**DRB CASE NO/PROJECT NO: 1003355**

**CITY OF ALBUQUERQUE  
PLANNING DEPARTMENT  
Development Review Board  
April 7, 2004  
Comments**

**RE: Lots 162 - 165, Town of Atrisco Grant/sketch plat**

**DEVELOPMENT REVIEW BOARD**  
**UTILITY DEVELOPMENT**  
**Standard Comment Sheet**

PLAT OF  
TRACTS 162-A, 163-A, 164-A,  
165-A, AND PARCEL "A"  
TOWN OF ATRISCO GRANT  
AIRPORT UNIT  
ALBUQUERQUE, BERNALILLO COUNTY, NEW MEXICO

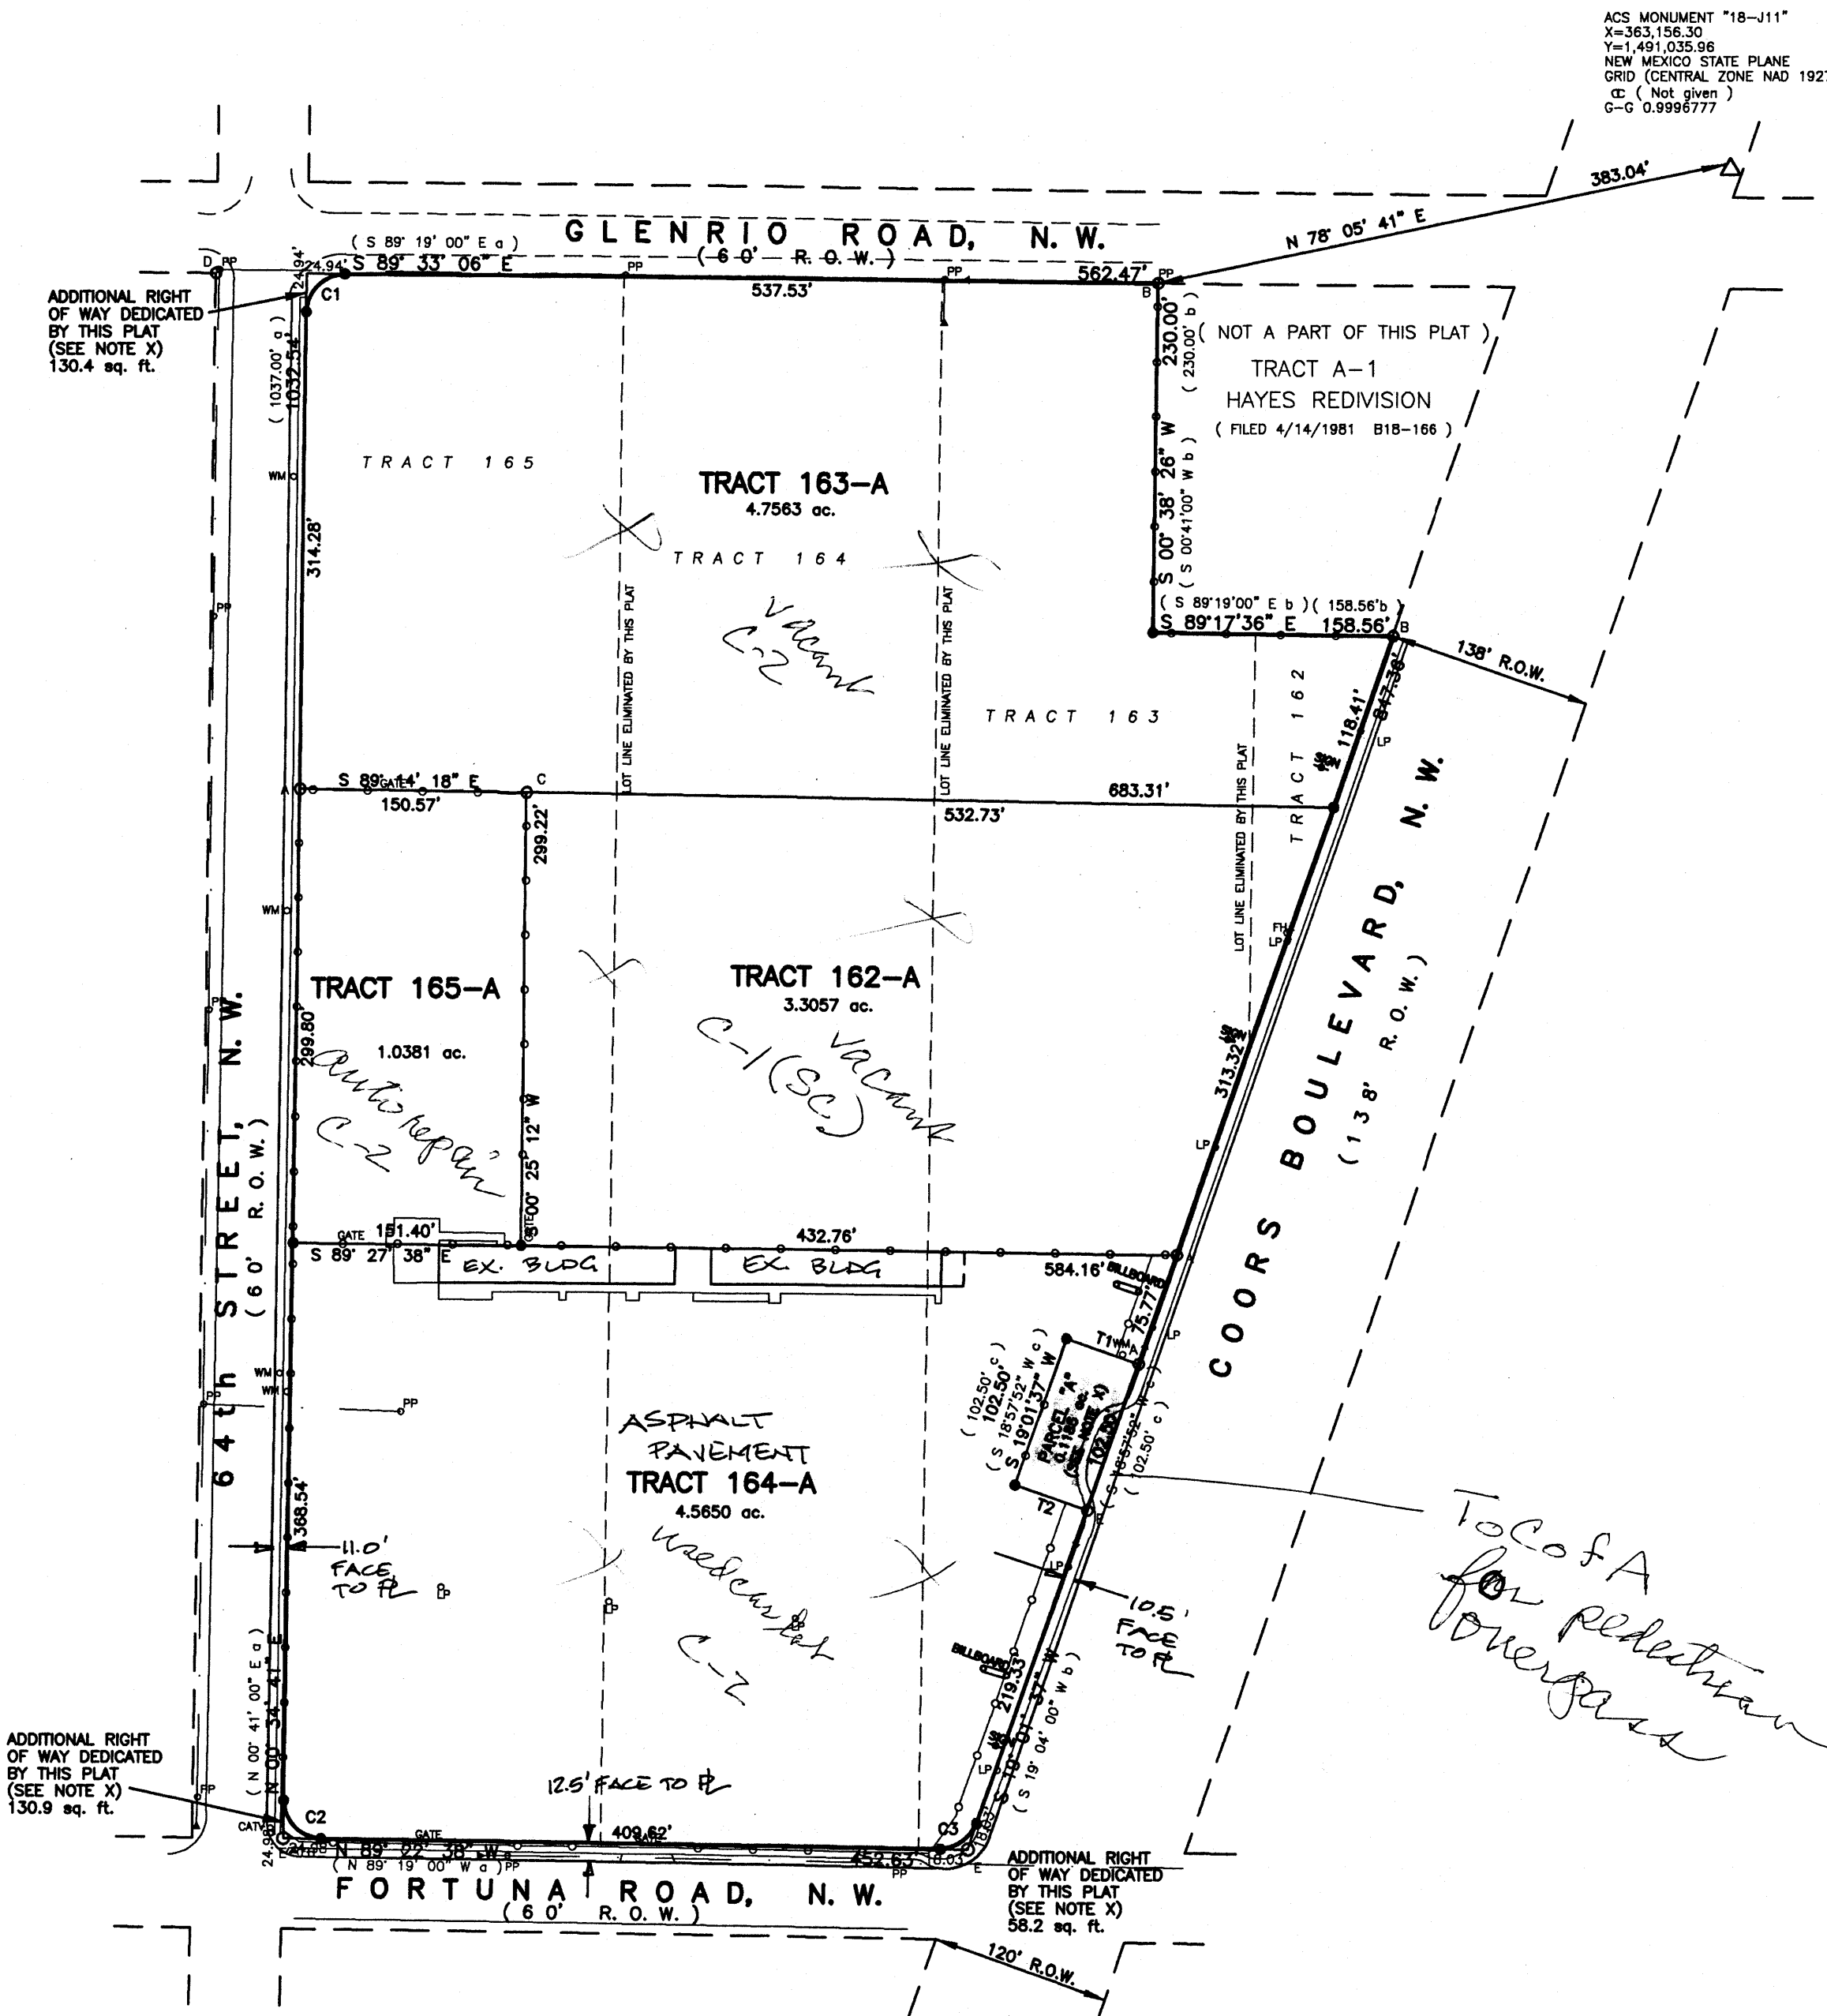
1. New Tract 165-A does not have access to sanitary sewer service. An easement must be provided to Coors across Tract 162-A, or a new sewer line must be constructed in 64<sup>th</sup>. The existing sewer line in 64<sup>th</sup> is a 48" dia. interceptor, and can not be used for service connections.

2. There is no water line in Glenrio, one may be required with the development of tract 163-A.
